STATE OF NORTH CAROLINA DEPARTMENT OF TRANSPORTATION

Addendum No. 1

RE: Contract # C204752
WBS # 54041.3.5
STATE FUNDED
Moore County (U-5815BA)
SR-2055 (N POPLAR ST) FROM ELM ST IN ABERDEEN TO NORTH OF BLUES
CROSSING LN IN SOUTHERN PINES

TRANSPORTATION MANAGEMENT PLAN

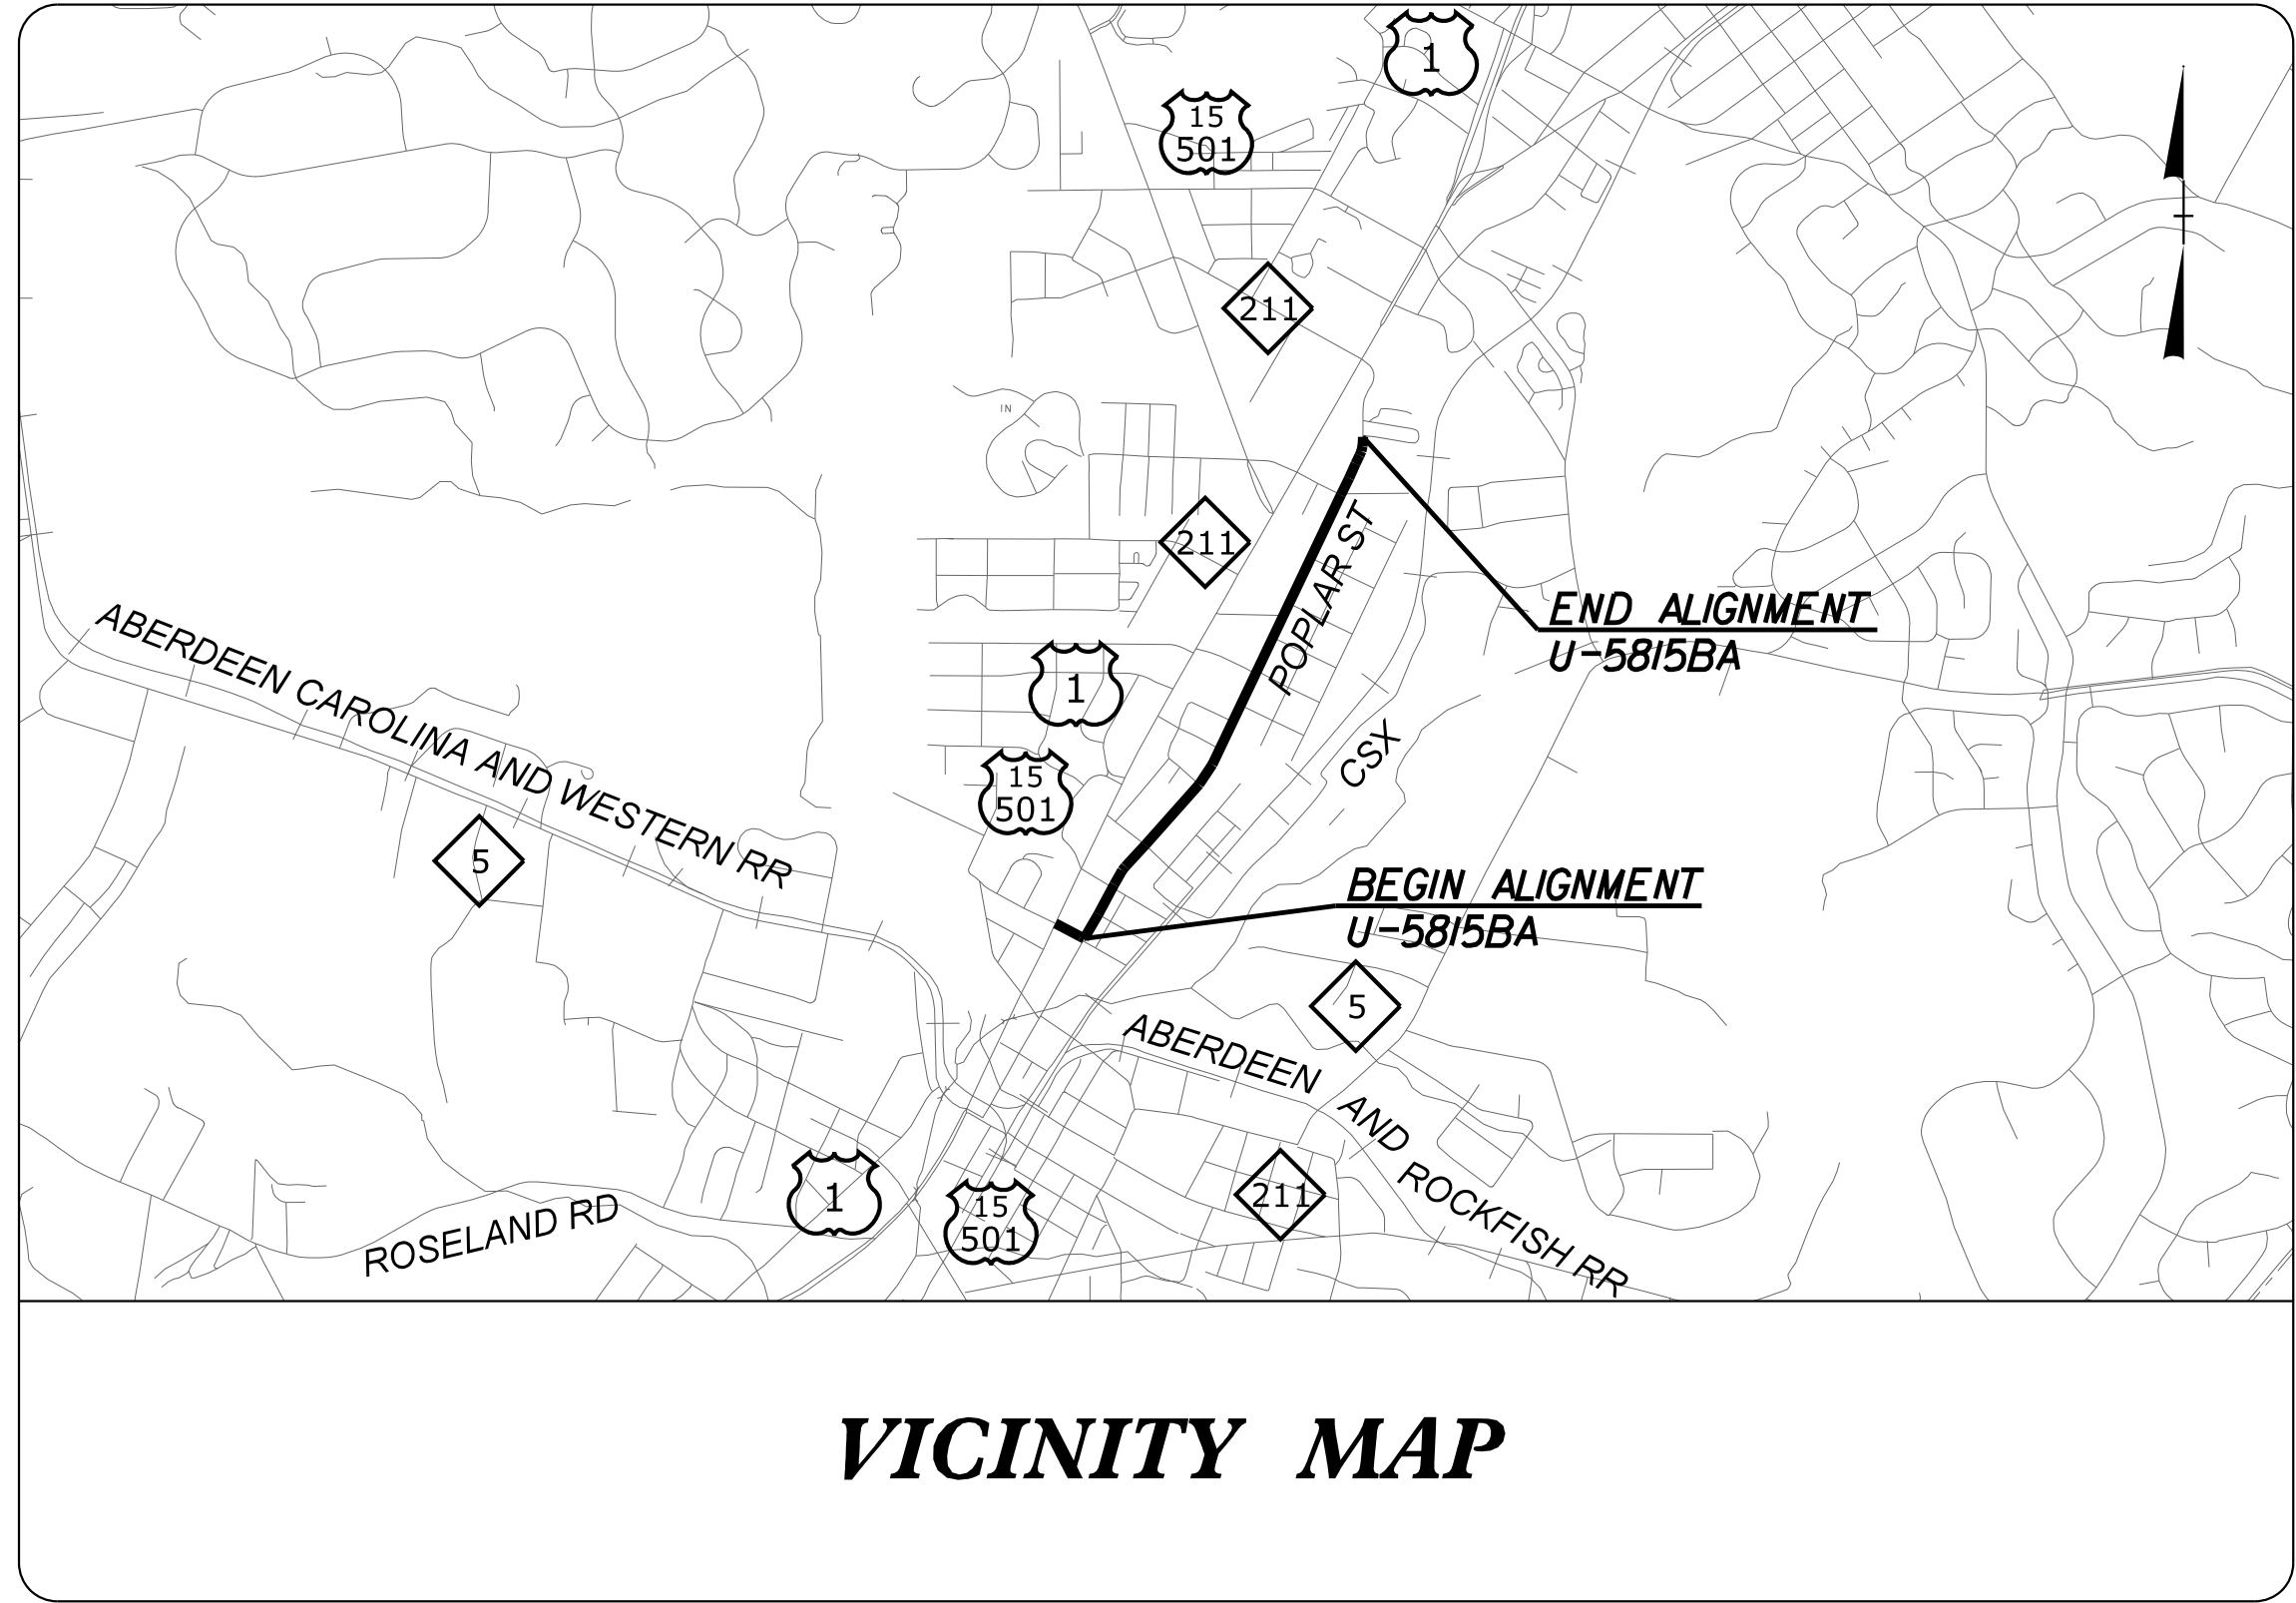
Sheet No.	Revision
TMP-1A	Under GENERAL NOTES, Time Restrictions have been
TWII-TA	revised/corrected
